# H2Teesside Project

The H2 Teesside Order

Document Reference: 8.25.2 Response to ExQ2.2 Assessment of Alternatives

**Applicant: H2 Teesside Ltd**

Plate 4-2: Water Management Options (Indicative)

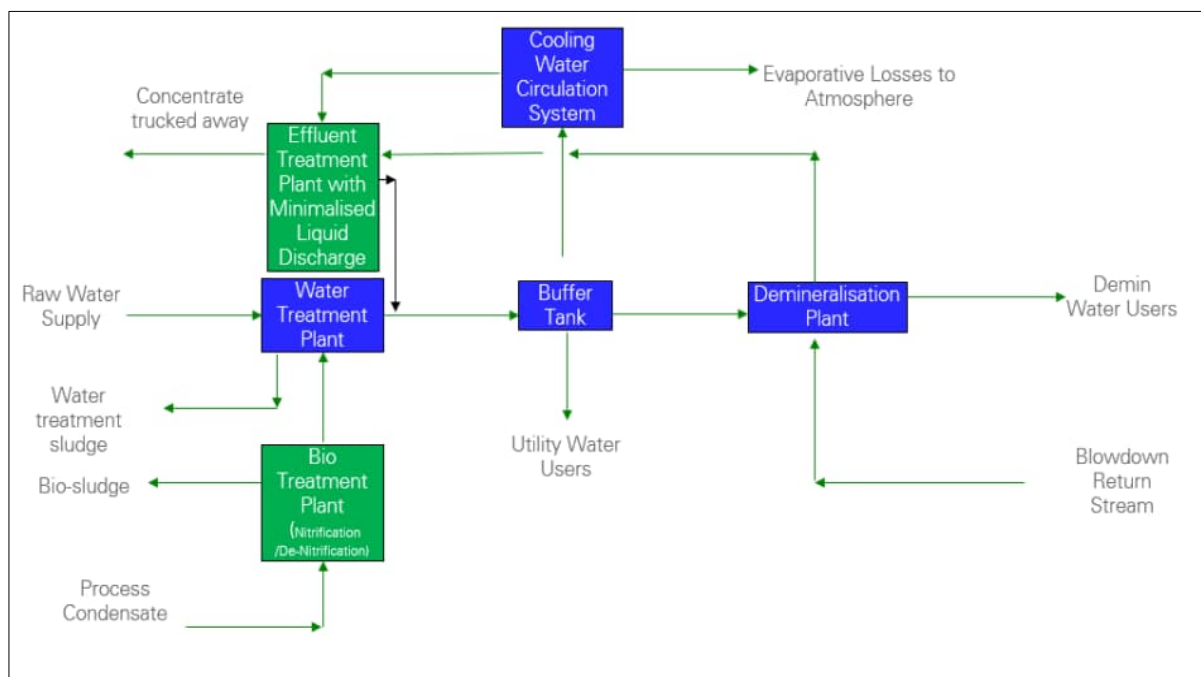
EXQ2	QUESTION TO:	QUESTION:	RESPONSE
Q2.2.1	Applicant	<p>The ExA notes your response at Q1.2.9 to its First Written Questions (ExQ1) [REP2-020] as well as the updated Report to Inform Habitats Regulations Assessment (HRA) [CR1-023]. It notes one of the two options proposed for effluent discharge has been removed, committing to the option involving discharge via the NZT outfall at Tees Bay (Case 2B) as the basis of the HRA.</p> <p>Removal of the alternative option (Case 1B) to transport Minimalised Liquid Discharge offsite is not included in the Change Application, but this is not surprising as it does not appear there would be any change to the infrastructure required or controls within the draft DCO arising from its removal. However, the ExA finds it a little confusing that only the Report to Inform HRA [CR1-023] refers to removal of Case 1B when it is still considered in other assessment work, eg the Nutrient Neutrality Assessment [APP-047], Water Framework Directive Assessment [APP-048] and Environmental Statement (ES) Chapter 9 Water Resources [APP-061], which have not been updated.</p> <p>Bearing the above in mind, please provide clarification that Case 1B has been removed and provide an explanation as to any implications for the draft DCO and/ or existing assessment work? If required, review the relevant Examination documentation, update it accordingly and enter such updated documentation into the Examination.</p>	<p>The Applicant can confirm that Case 1B (offsite transportation of Minimalised Liquid Discharge) has been entirely removed as an option. This was not included in the Change Application as it merely reflects the selection of the preferred approach, namely discharge via the NZT outfall at Tees Bay (Case 2B), therefore, no update is required for the existing assessment work.</p> <p>Regarding the implications for the draft DCO [REP4-004] and assessment work, the Applicant notes the following:</p> <ol style="list-style-type: none"> <li>1. The removal of Case 1B has no impact on the infrastructure or controls specified within the draft DCO [REP4-004], as these were designed to accommodate both options.</li> <li>2. The Change Application Report [CR1-044] identified and updated only those chapters and documents where the change had a potential material impact. For Case 1B, no such updates were necessary since both options were considered from the outset, and the assessments already accounted for either approach.</li> </ol> <p>The Applicant acknowledges the ExA’s observation that some existing documents, such as the Nutrient Neutrality Assessment [APP-047], Water Framework Directive Assessment [APP-048], and ES Chapter 9 Surface Water, Flood Risk and Water Resources [APP-061], still reference Case 1B, however, would note that Case 1A forms the basis of these assessments so the removal of Case 1B makes no material difference to the assessments.</p> <p>The Report to Inform HRA was updated in response to NE’s relevant representation on the Proposed Development, with the choice to remove Case 1B simply included as part of this wider update for efficiency purposes.</p>
